## **WRITTEN REPRESENTATION OF MINSMERE LEVELS STAKEHOLDERS GROUP (MLSG)**

### **Minsmere Levels**

### **Representation**

Figure 6: Topographic maps of the current and proposed SCDF topography.

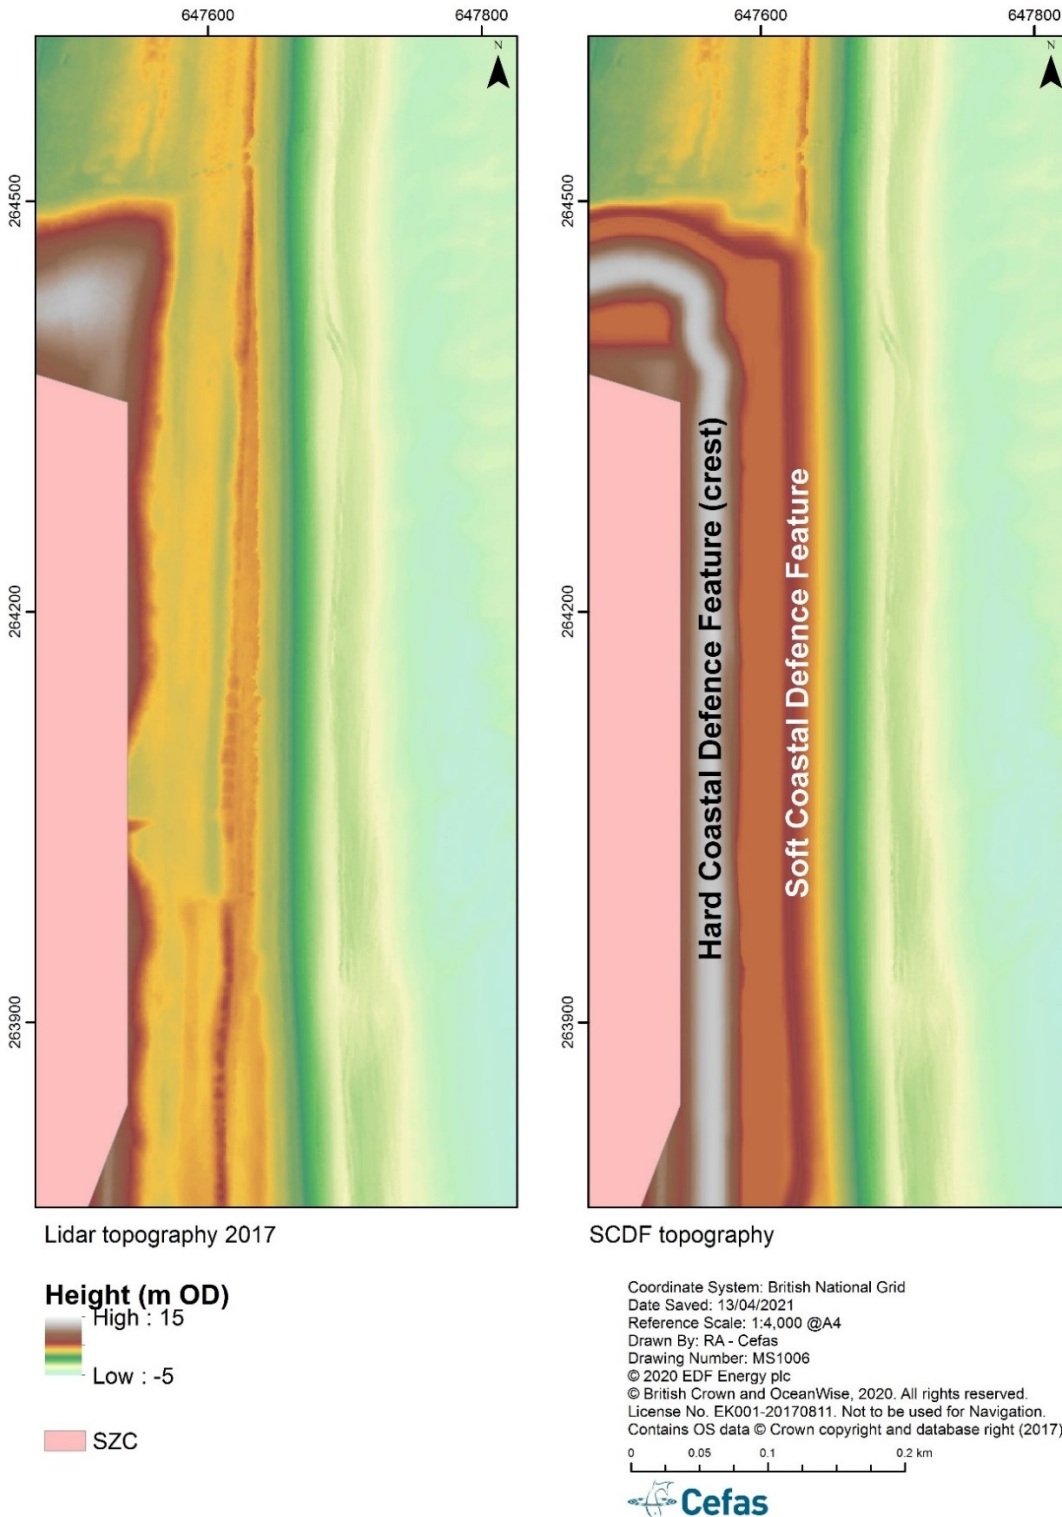
- The Hard Coastal Defence Feature (HCDF) toe at 0m OD will be subject to undermining by wave action if exposed. Reliance on the proposed Soft Coastal Defence Feature (SCDF) is unproven and unrealistic given the episodic nature of coastal erosion on the Suffolk coast.

- No design for the HCDF has been made available for examination, yet SZC Co have unevidenced confidence about its likely exposure and have submitted a Coastal Processes Monitoring and Mitigation Plan without a design being available to assess it against.

- The current parameter plans and HCDF Figures are too vague to be of use in any assessments. Figures 2.2.20, 2.2.22 and 2.2.25 in Environmental Statement Addendum, Vol 2, Chapter 2 ([AS-190](#)) alongside the Main Site Parameter Plan ([AS-118](#)) are insufficient to define the construction and location of the combined defence and their relationship to the existing sacrificial dune and beach.

DRAWING NO:
SZC-SZ0100-XX-000-DRW-100205

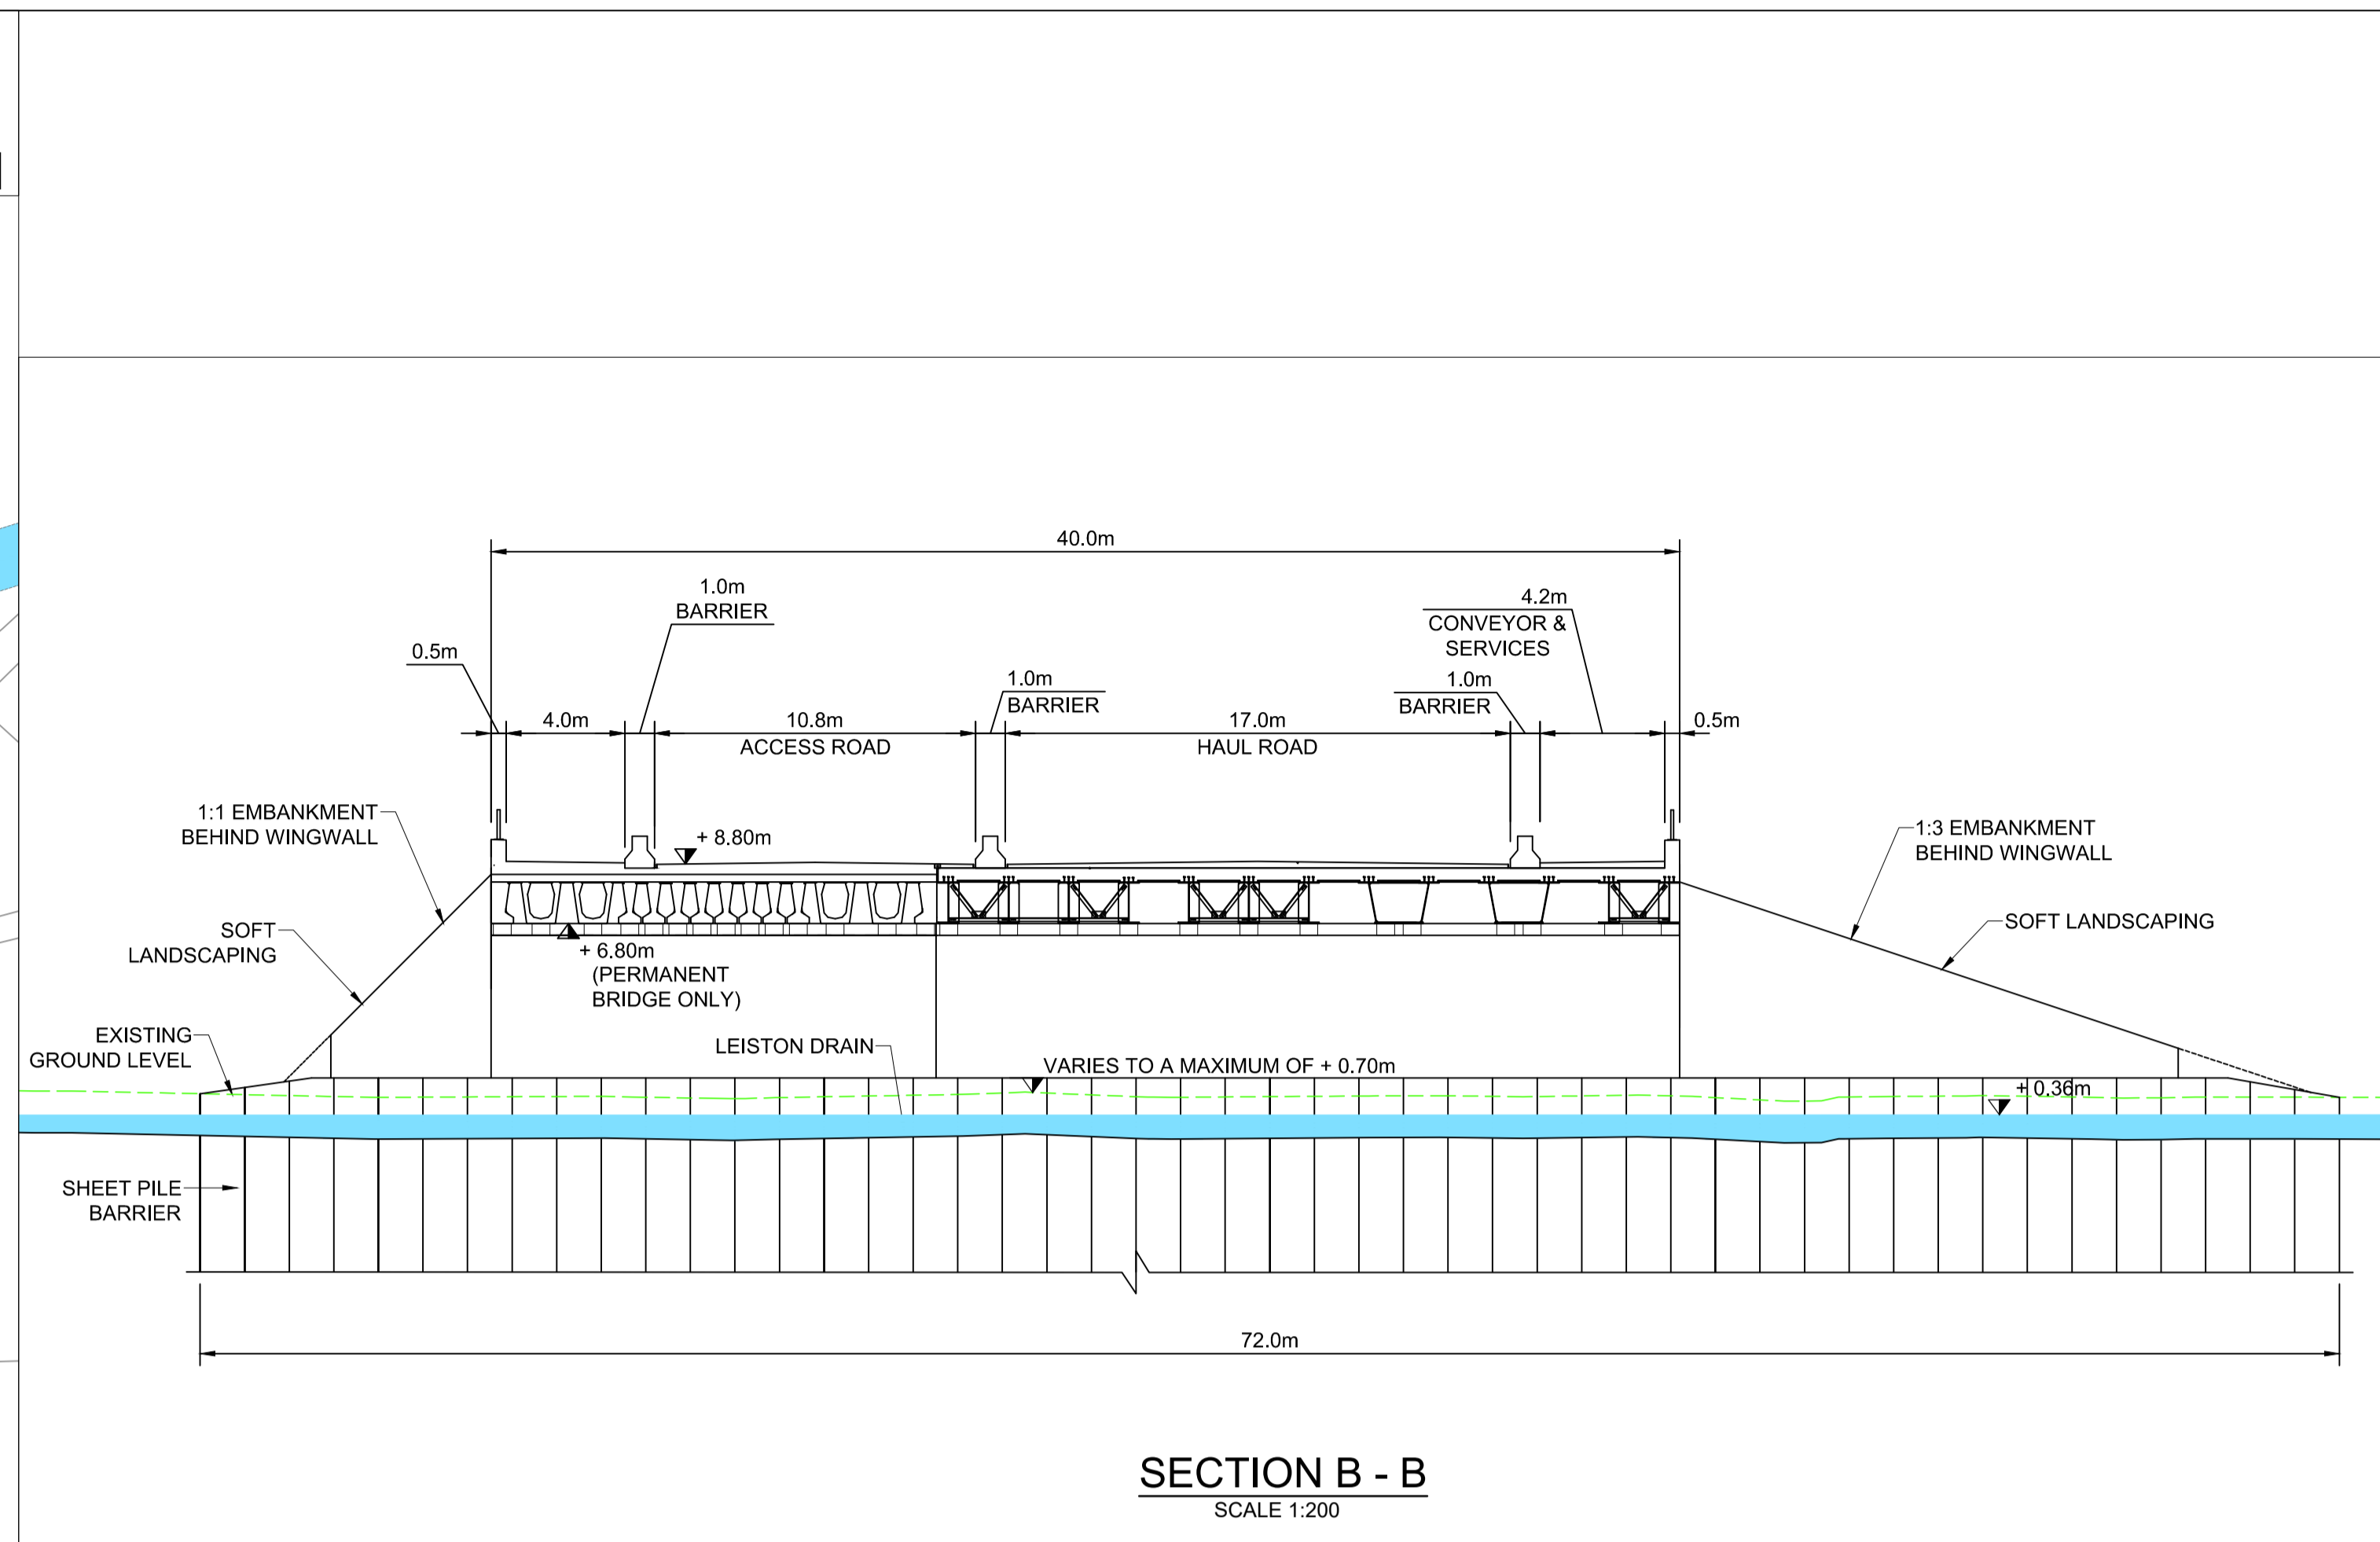
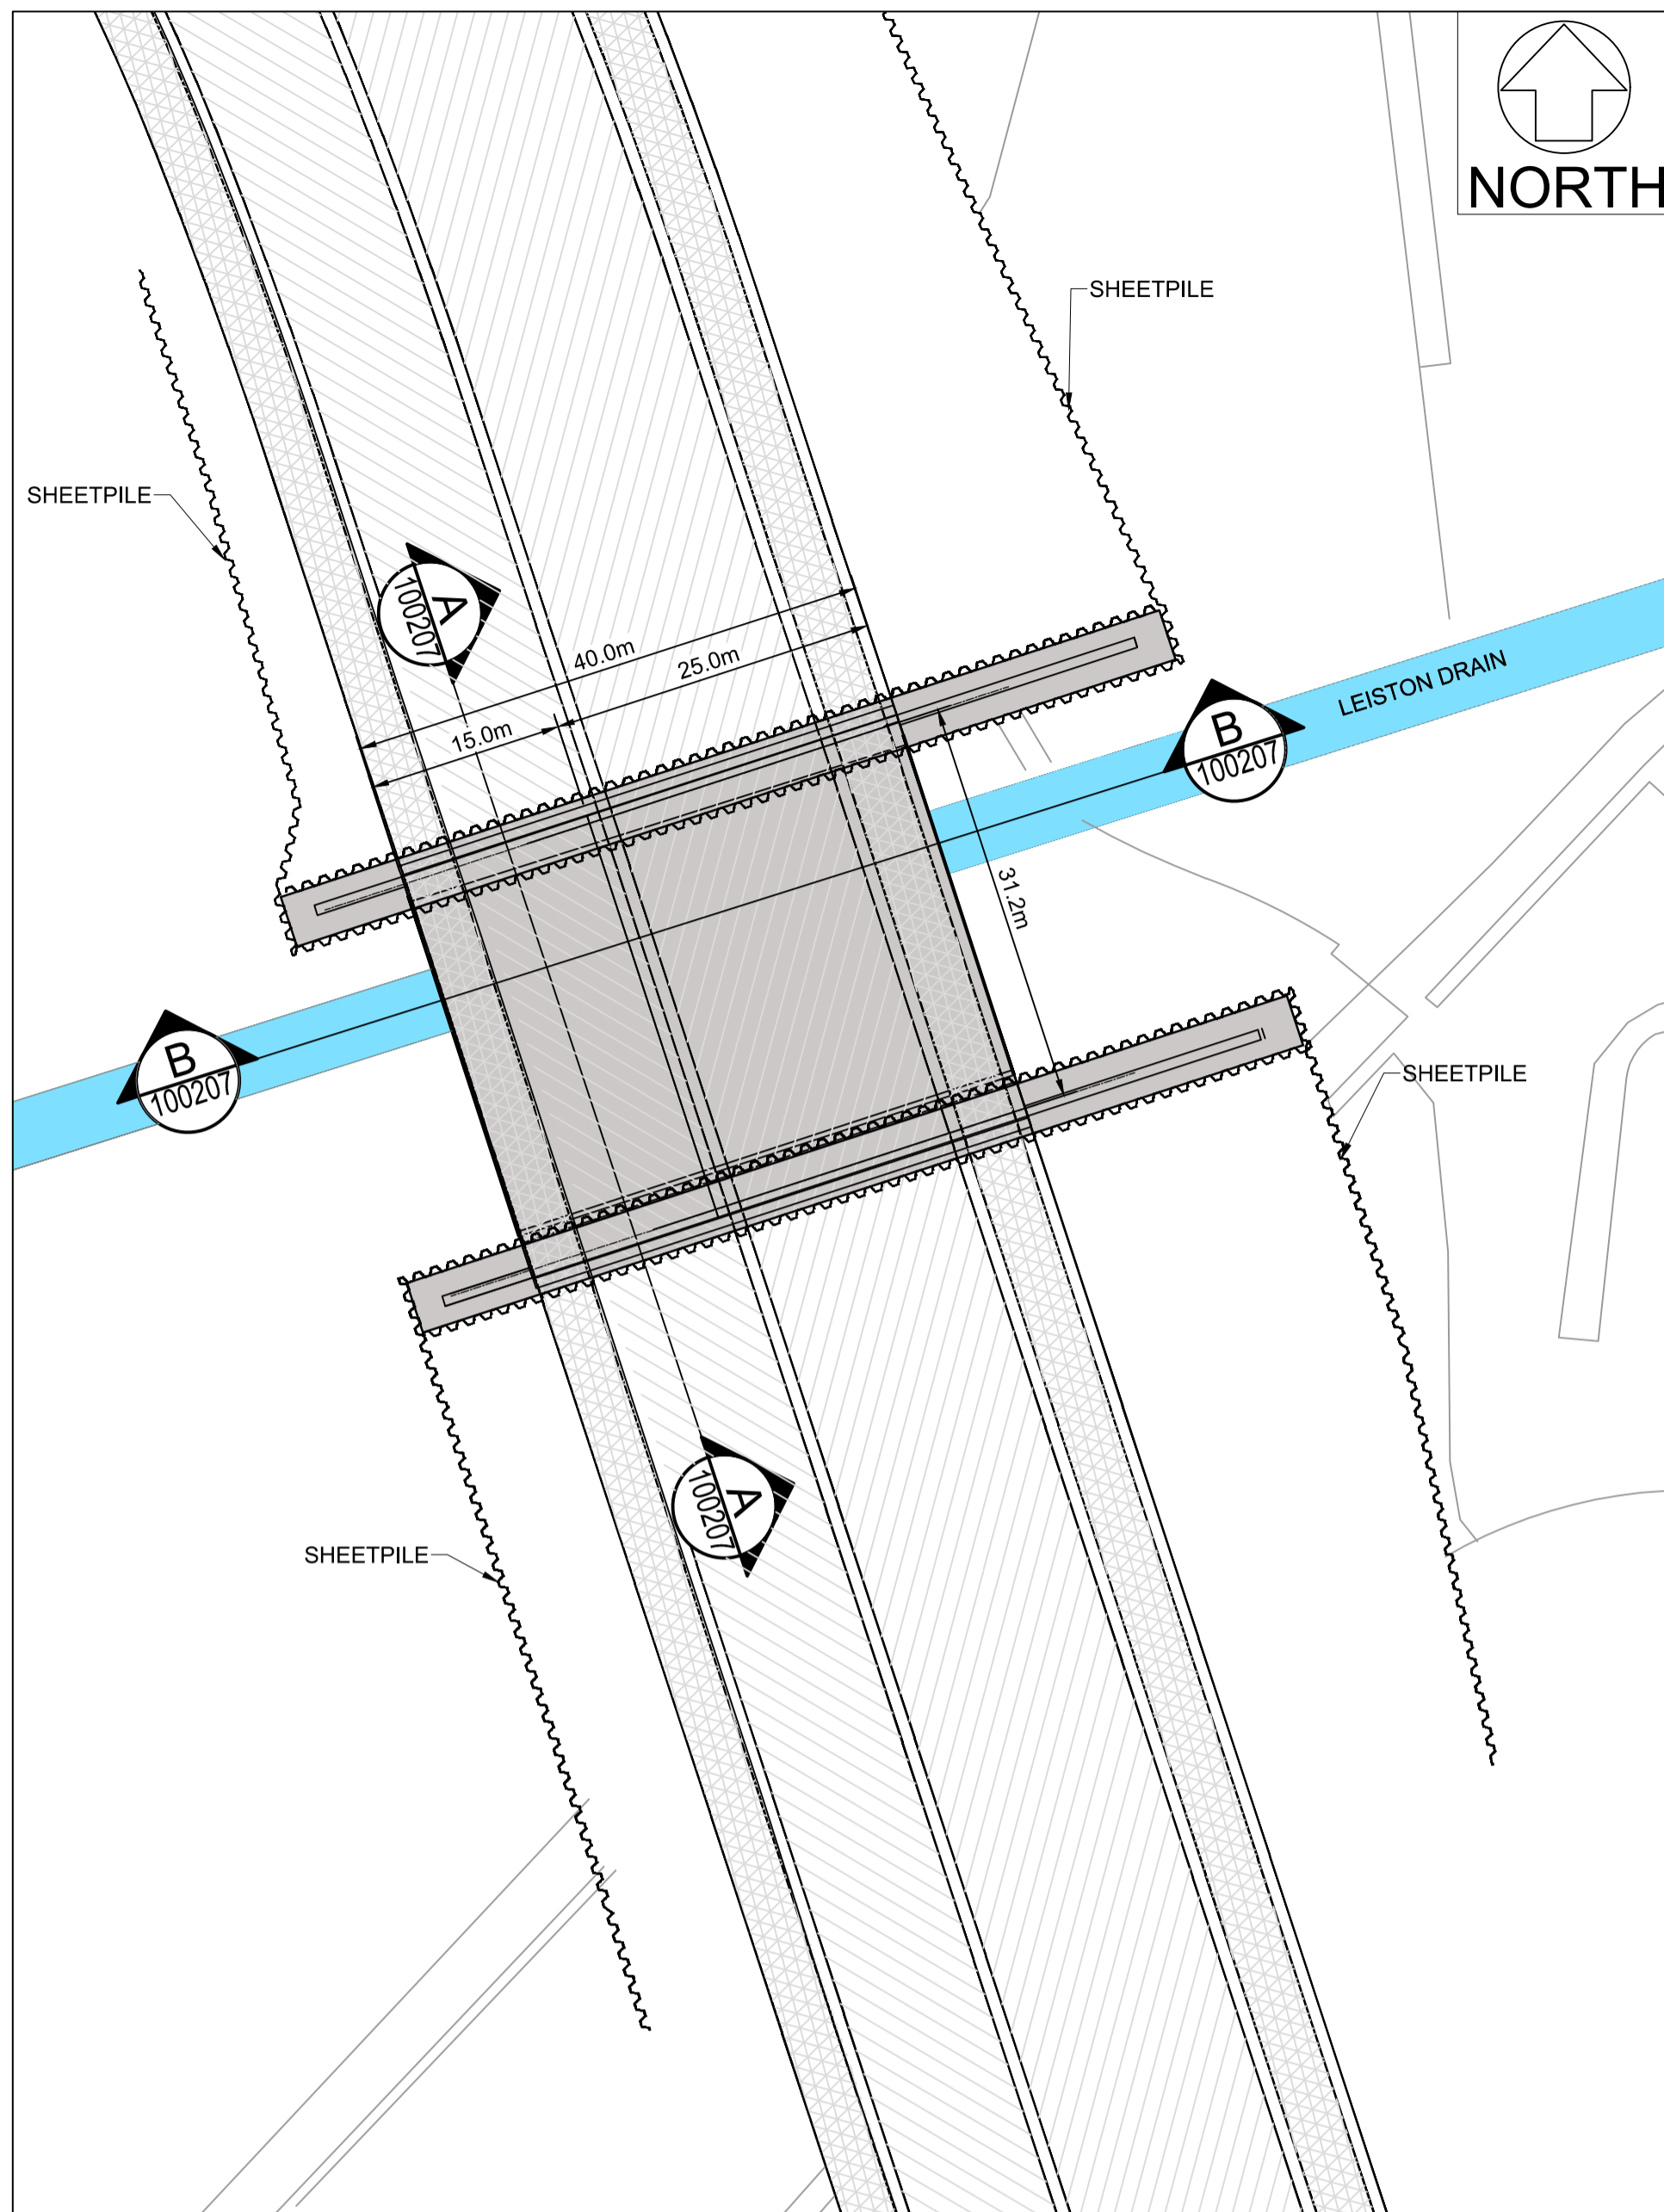
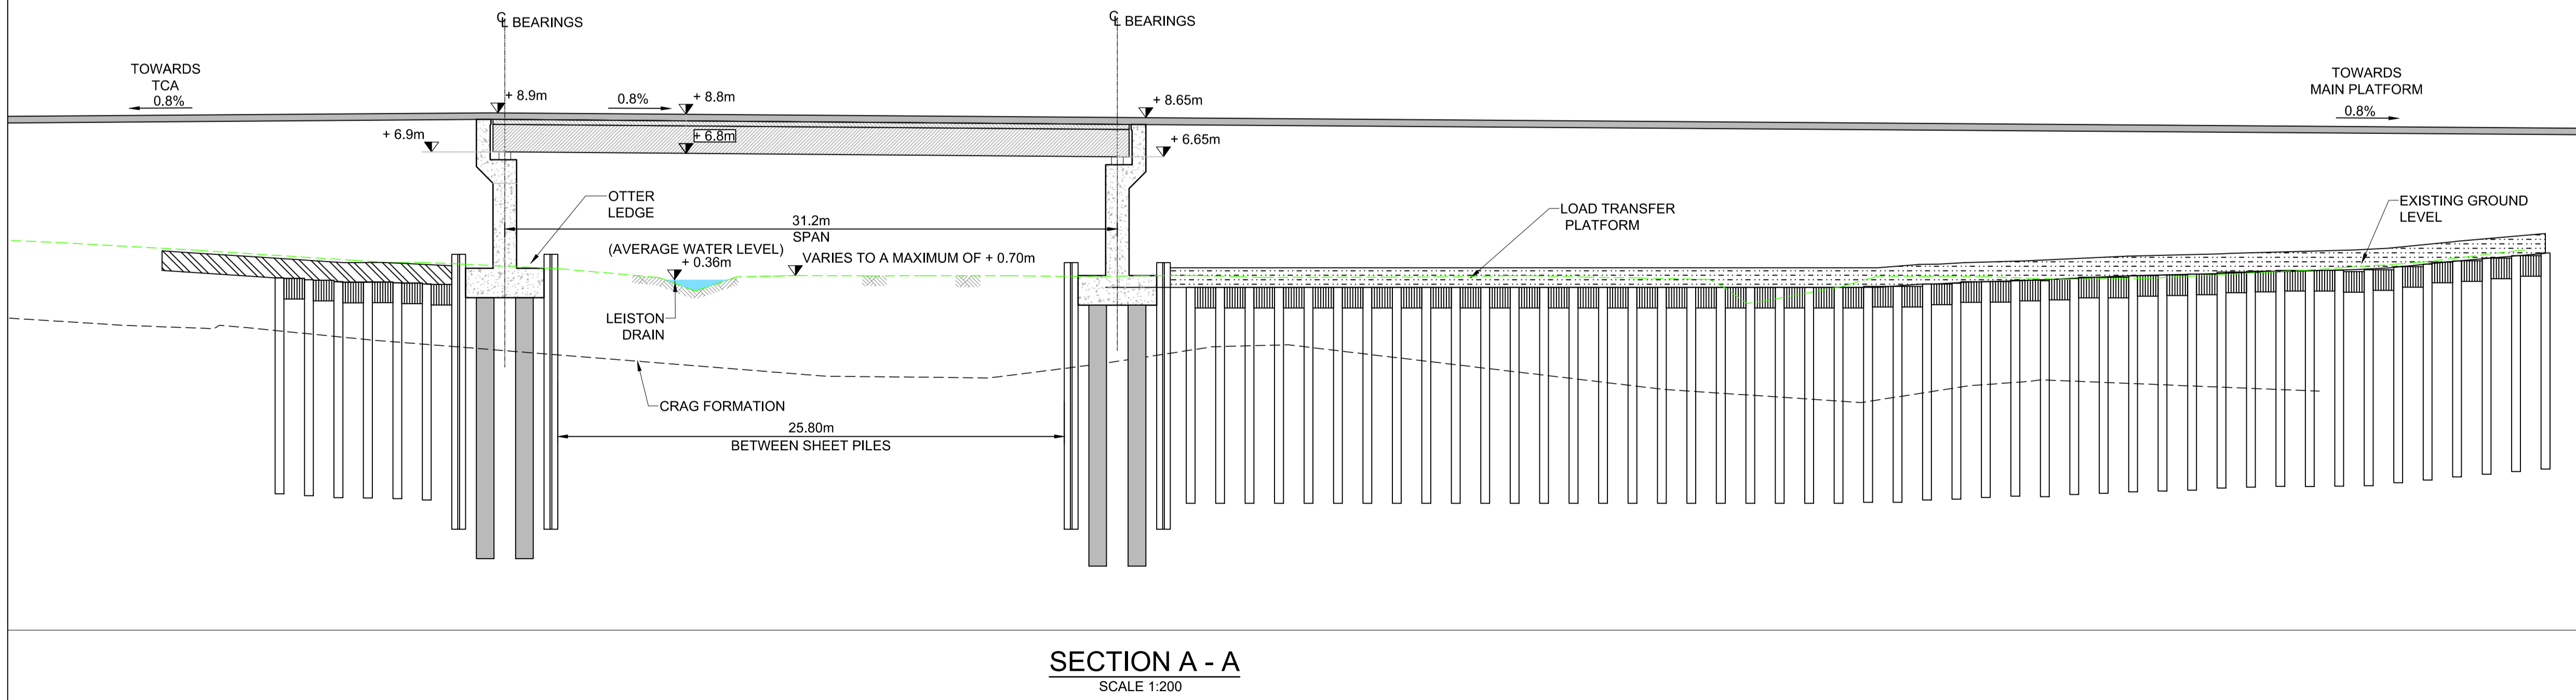
- The permanent Beach Landing Facility (BLF) will be the most north easterly point of the construction site and with its undefined HCDF protection will be a significant groyne when exposed. No design, beyond the piles, roadbed and docking facilities, for its integration with the HCDF have been presented and, perhaps more than any other part of the HCDF, this structure will be the most impactful on coastal processes.

- We consider SZC Co's assessment of the impact of both the HCDF/SCDF and BLF to still be inadequate on a number of points and defer to Mr Nick Scarr's submission [AS-028](#) and updates that may be submitted at Deadline 2. We believe the reliance on the existing CPMMP is inappropriate given no plans of the permanent BLF, HCDF and SCDF in relation to the existing coastal frontage has been made available.
